Subject: New comments for application 19/01746/OUT

New comments have been received for application 19/01746/OUT at site address: Land Adj To Promised Land Farm Wendlebury Road Chesterton

Fig. 27 Proposed infrastructure plan, DTA drg no 19539—11—12 Wendlebury Road Site Access Roundabout

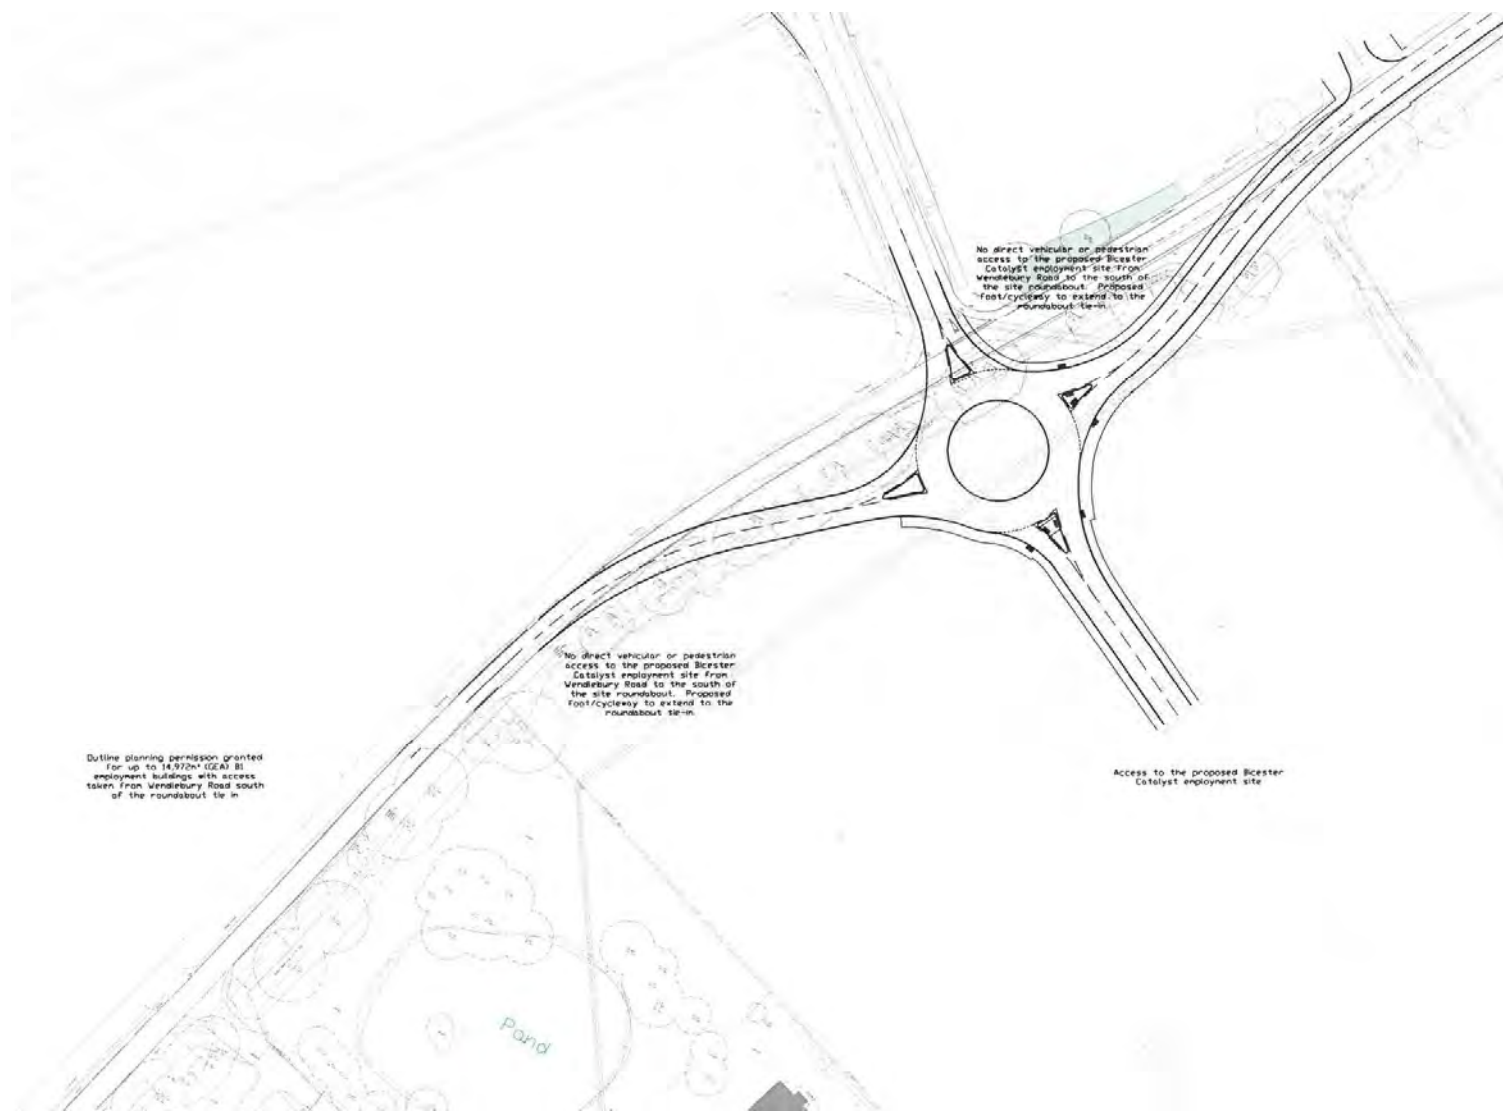
## 4 NEW ROUNDABOUT SHOULD PROVIDE A PROTECTED CYCLE LANE.

In line with the additional car and HGV Traffic (quoted as being 600-1800 cars/hr and 1000-3000HGV's per day) then a segregated cycle path with priority over adjoining roads in a 'dutch style' roundabout not only should be considered but should be of paramount importance. Bicester Social Cycling along with BicesterBUG reject the claim that the traffic level is below a supposed 'intimidation threshold.'

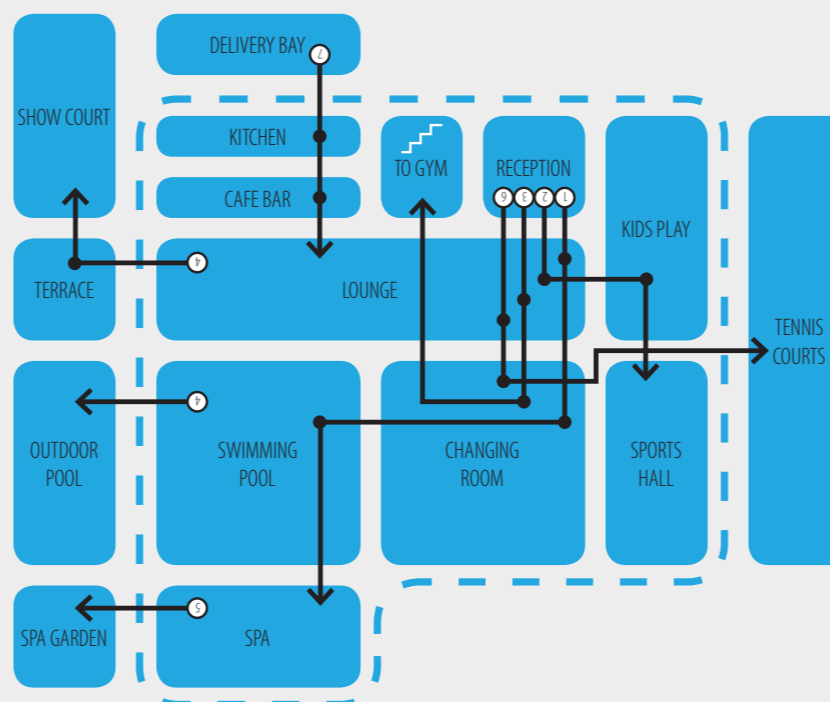
250 car parking spaces have been allocated but only 20 cycle spaces, this indicates insufficient ambition towards Active Travel and could well contravene the OCC guidelines of 1 space per 150m<sup>2</sup>.
